Our ref: NE/2023/136256/02-L01

Date: 31 October 2023

**Application by London Luton Airport Limited for an Order granting
Development Consent for the proposed London Luton Airport Expansion
Project: The Examining Authority's Written Questions and requests for further
information**

Luton Airport, 2 Percival Way, Luton, LU2 9LY

Inset 3: Preliminary design of ~~Southern~~ Infiltration Tank 2 (from DDS, **Appendix 20.4** of the ES [TR020001/APP/5.02])

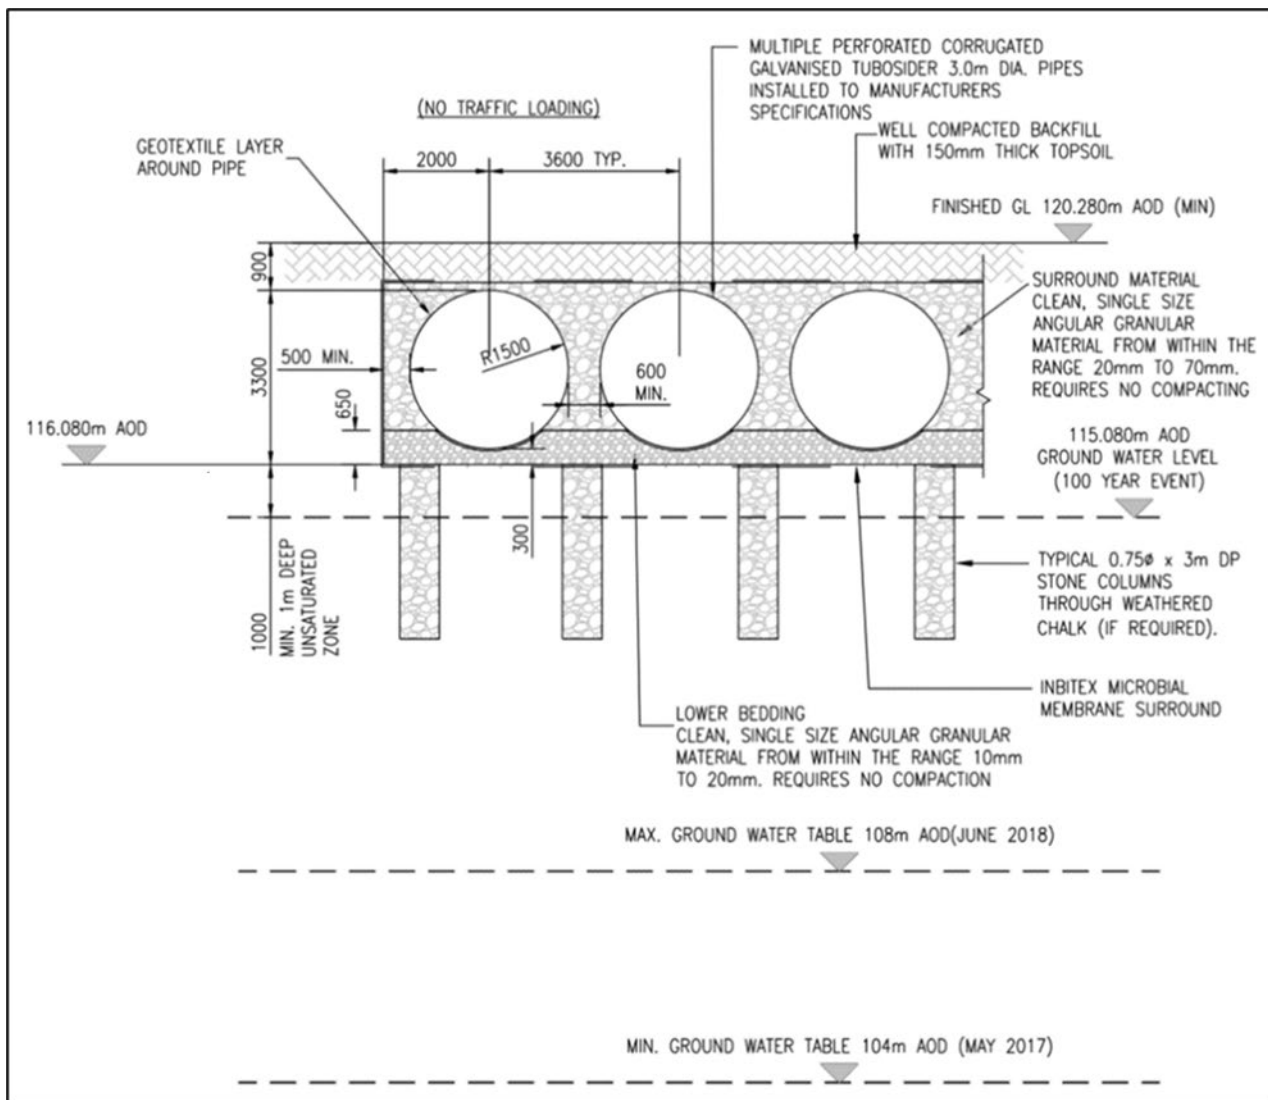
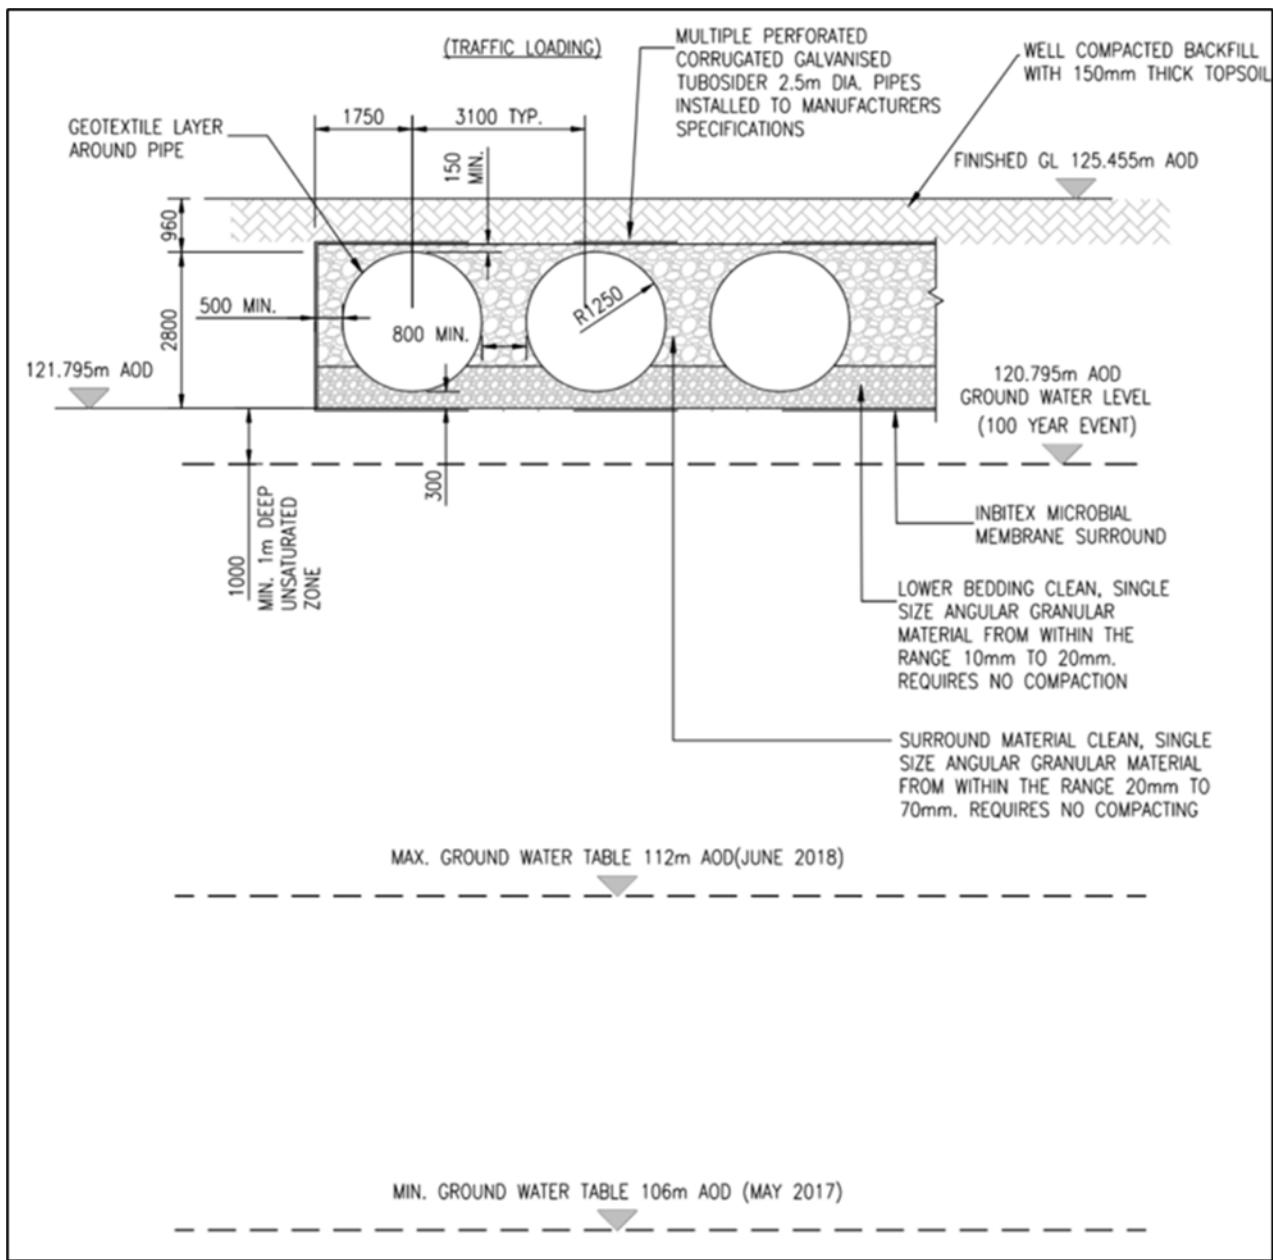
<p>However, we would expect the tank to be installed to a high standard with consideration for the potential for differential settlement and for the mobilization of other hazardous substances within the surrounding landfill material should there be a failure. We would also require a risk assessment, considering the potential for leakage from the underground tank, to be provided. The risk assessment should include reference to monitoring and maintenance activities that will be adopted to enable the operator to identify if the tank is leaking and reference to specific actions that will be completed if leakage is identified.</p> <p>Recent discussions with the applicant have highlighted that these plans are not yet finalised and that further options will be looked at. Our concerns were also noted. The EA raised in this meeting that tanks located in a room where they could be inspected would be more preferable than any design where the tanks are set straight into the ground. Moving the tanks to areas outside of the landfill would cause much less concern. As such, at this moment in time we cannot confirm if the outline design for these tanks is suitable.</p>
